GLENEAGLE GOLF COURSE RESIDENTIAL INFILL DEVELOPMENT, FIL #2

DRAINAGE, GRADING & EROSION CONTROL PLAN OVERALL

GLENEAGLE
 SUBDIVISION FIL #2

DRAINAGE, GRADING &
 EROSION CONTROL
 PLAN

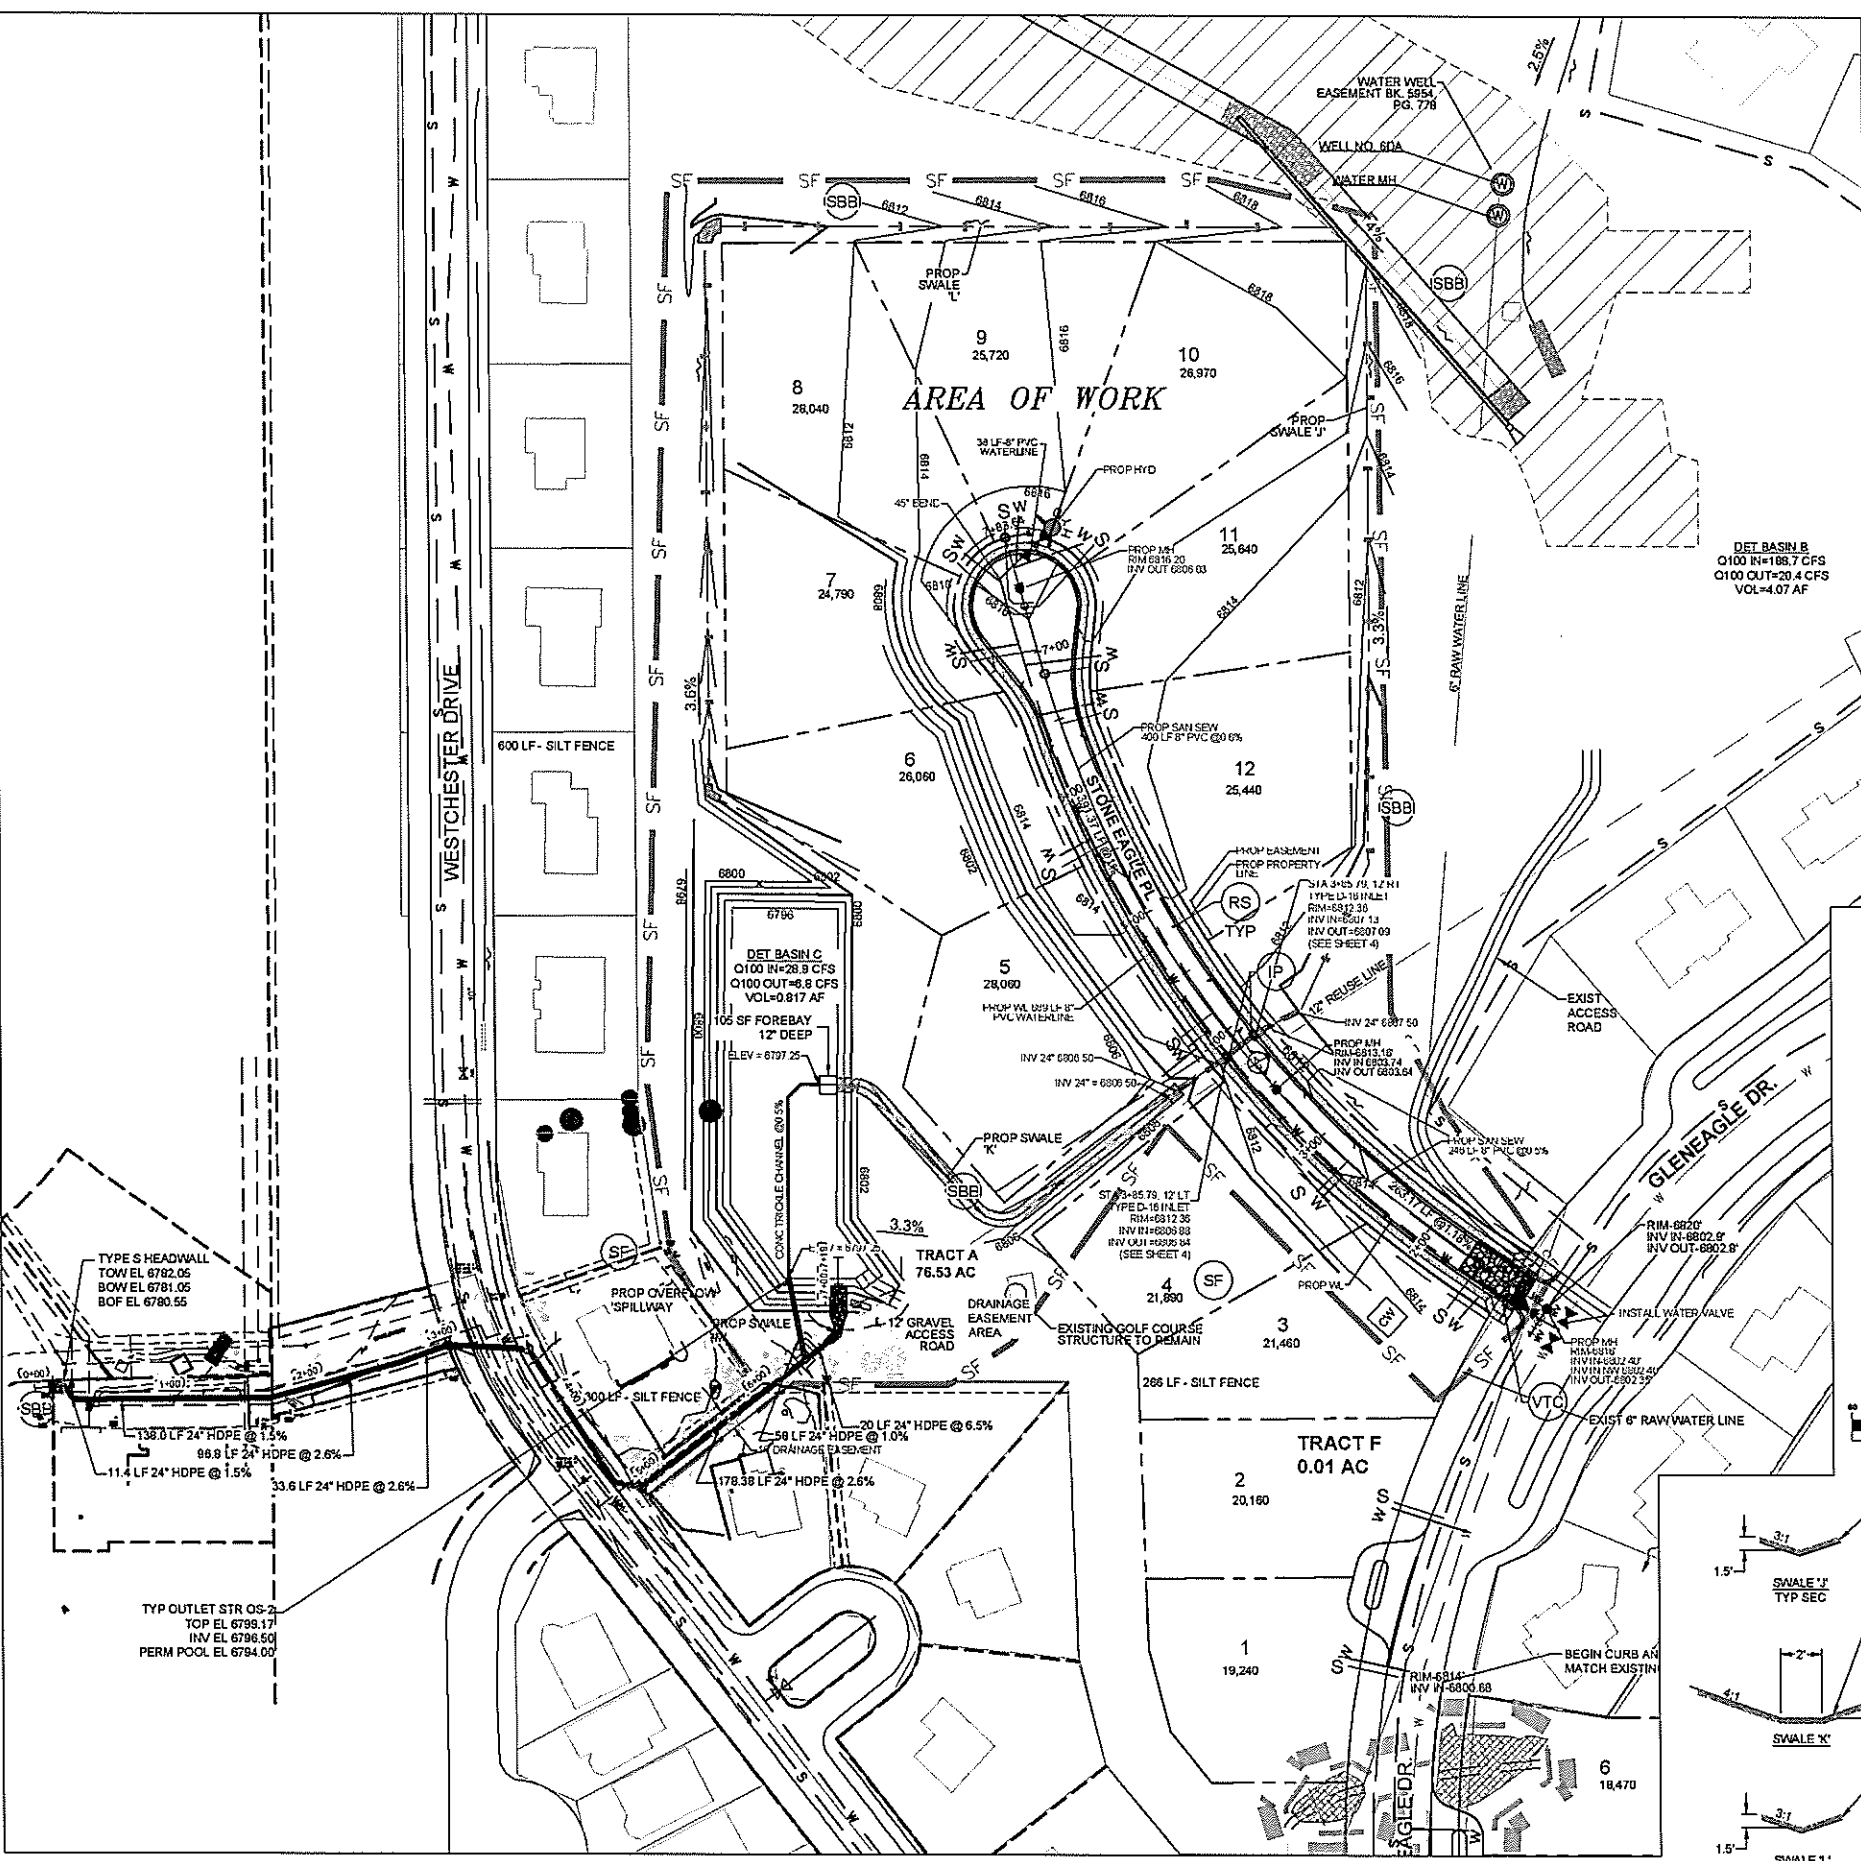
Filed in accordance with the El Paso County Land Development Code, Drainage Criteria Manual Volumes 1 and 2, and the Engineering Criteria Manual, as amended. This is part of the County Engineer signature block. Please remove.

VR-18-018 **SHEET 2**

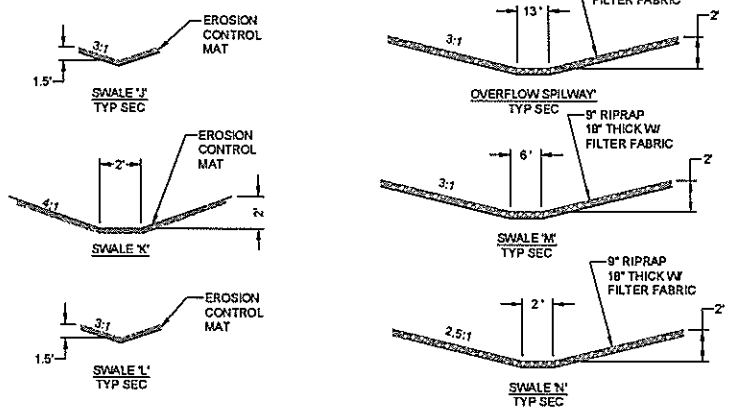
See inlet details sheet 4 of 4 of the Construction drawings.

Call out Type C inlet or a manhole lid that will capture ditch flows. (Standard detail SD_3-5 175# lid?) See drainage report comments.

Please include Storm Sewer Plans on the Construction Plan set.
